From: Michael Eastham <Michael.Eastham@arun.gov.uk>
Sent: 07 December 2020 08:08
To: Planning.Responses <Planning.Responses@arun.gov.uk>
Subject: FW: *EXTERNAL: A/179/20/RES - Land South of Water Lane, Angmering

Please upload onto Ocella the email below which is a further consultation response from **WSCC Fire & Rescue Service** to reserved matters application **A/179/20/RES**.

Please see the email below from Sean Havis at BDW and find attached an amended plan for reserved matters application **A/179/20/RES** relating to the culverted embankment on Land South of Water Lane, Angmering.

WATER LANE, ANGMERING
PROPOSED ACCESS
VEHICLE SWEEP PATH ANALYSIS
DUO RECYCLER

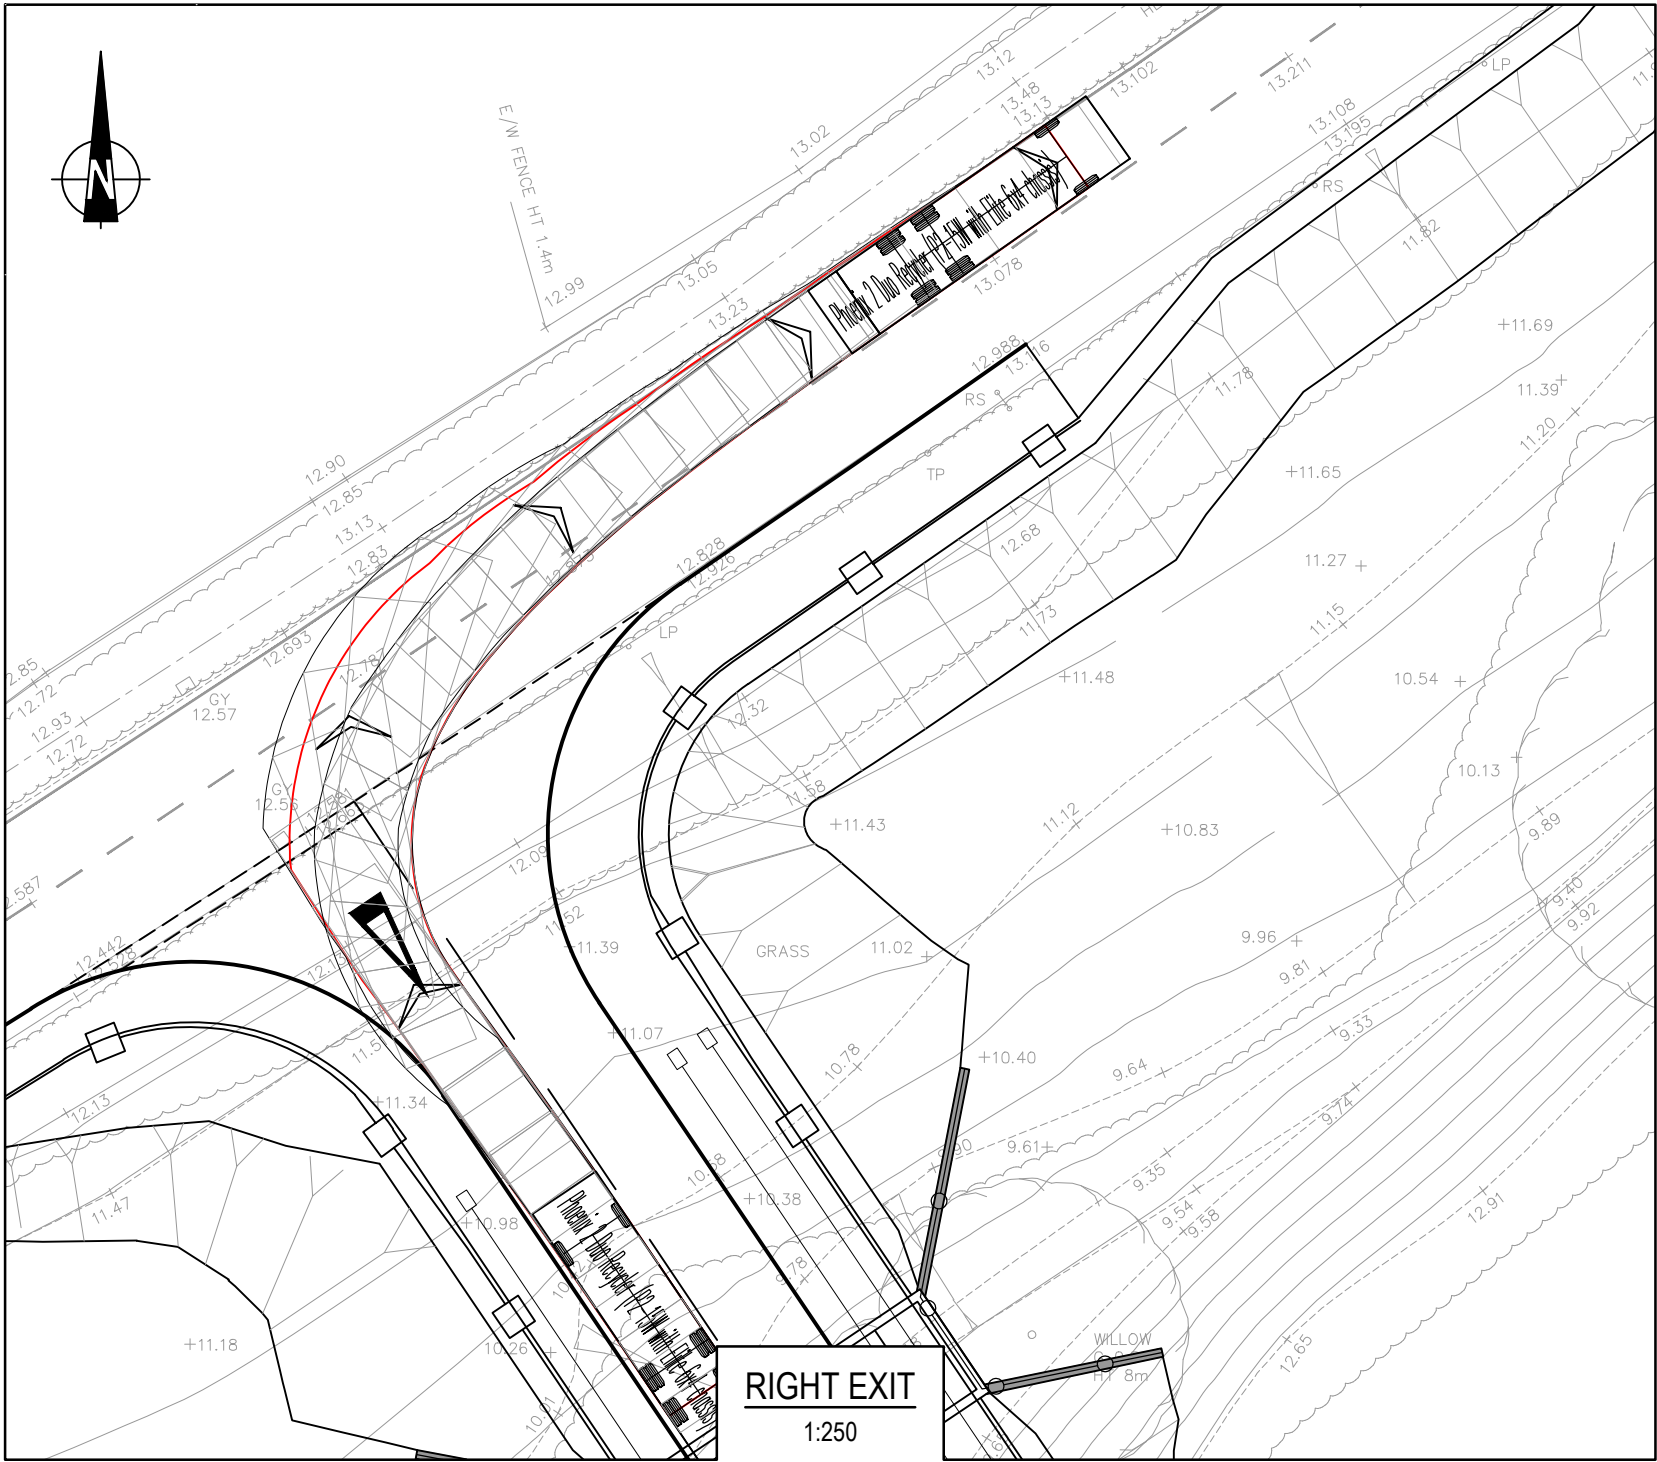
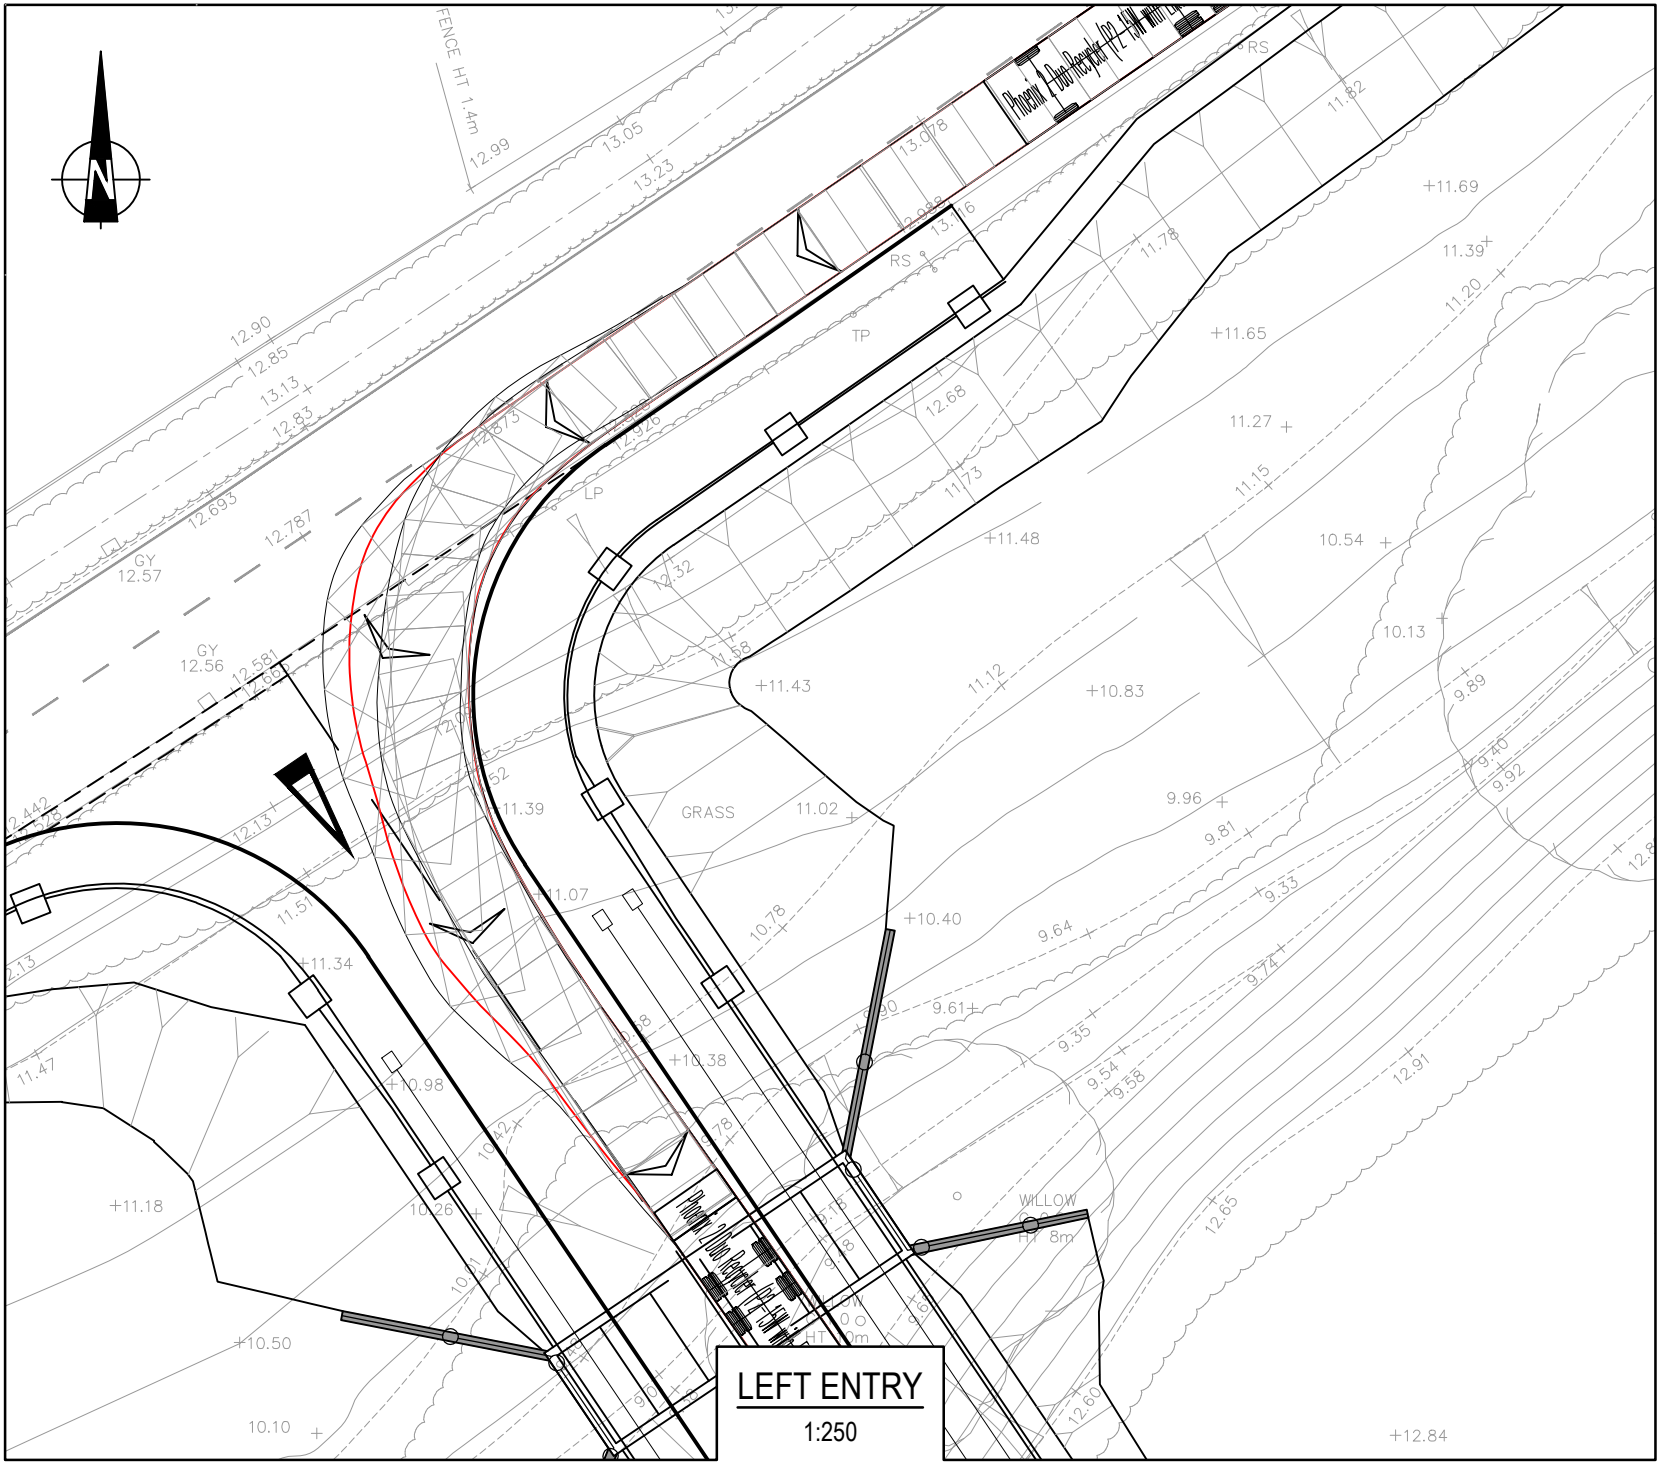
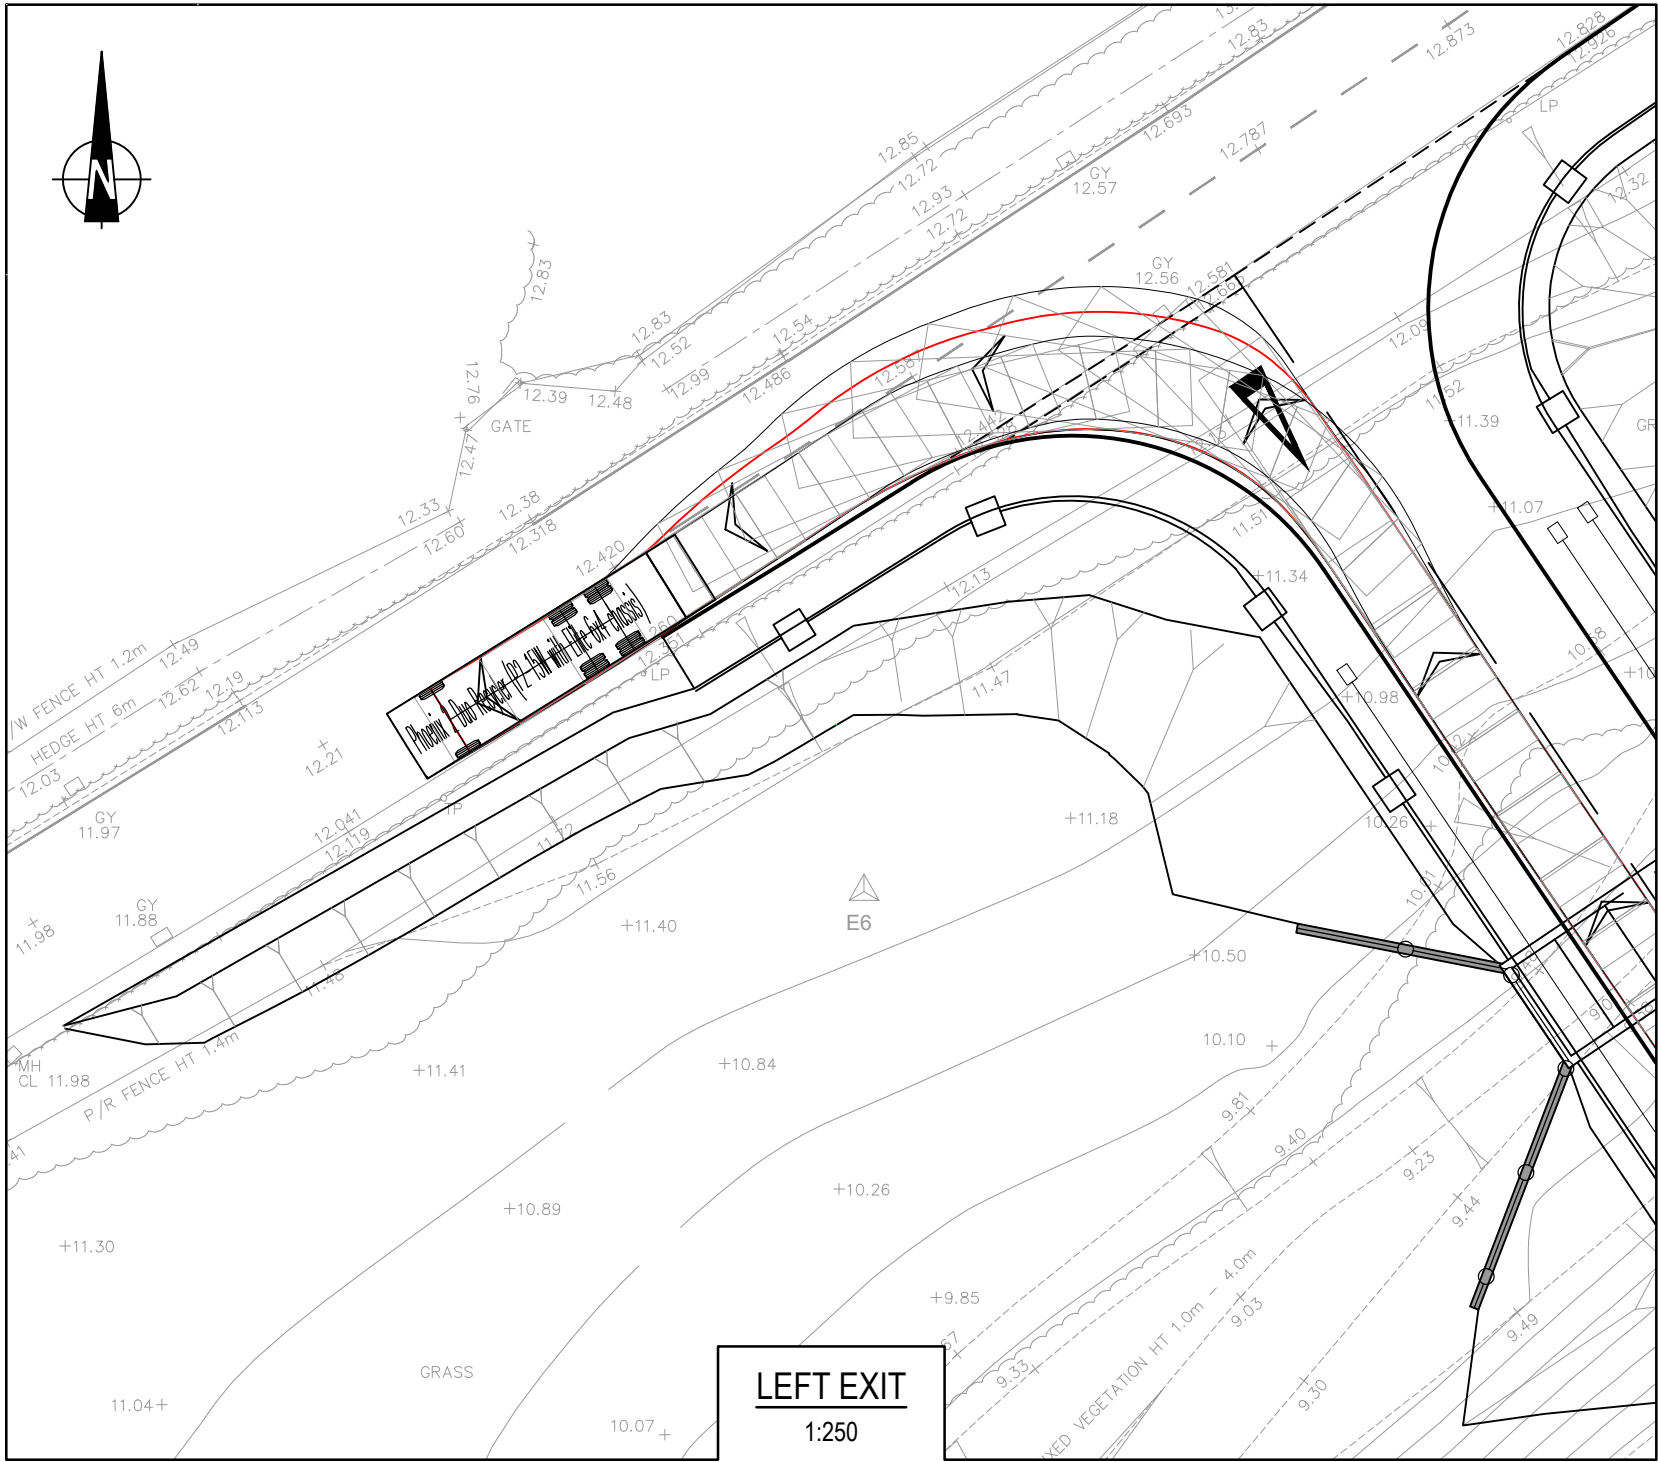
Evidence would be required that there is sufficient access width for a fire appliance to access the site. The road would need to be sufficiently wide enough to allow a fire appliance to gain access with a minimum width of 3.7 metres and capable of withstanding 12 to 17 tonne axial weight.

Evidence would be required that there is sufficient access width for a fire appliance to access the site. The road would need to be sufficiently wide enough to allow a fire appliance to gain access with a minimum width of 3.7 metres and capable of withstanding 12 to 17 tonne axial weight.

Thanks you for the response to our consultation, the plan does demonstrate suitable access onto the site, however there has not been a site layout plan submitted to allow the Fire Service to assess the access to all premises,. This I assume will be submitted at a later date as this application was for access only.

In regard to the other two queries from the Local Highway Authority and WSCC Fire & Rescue Service, please find the attached revised plan (General Arrangement - 46353_2002_020_A) illustrating the crossing over Water Lane connecting into the footway/cycleway running north and east. The attached plan also demonstrates that the width of the carriageway is 6m, significantly exceeding the 3.7m requirement. I can also confirm that the culvert will be constructed to be capable of withstanding 12 to 17 tonne axial weight.
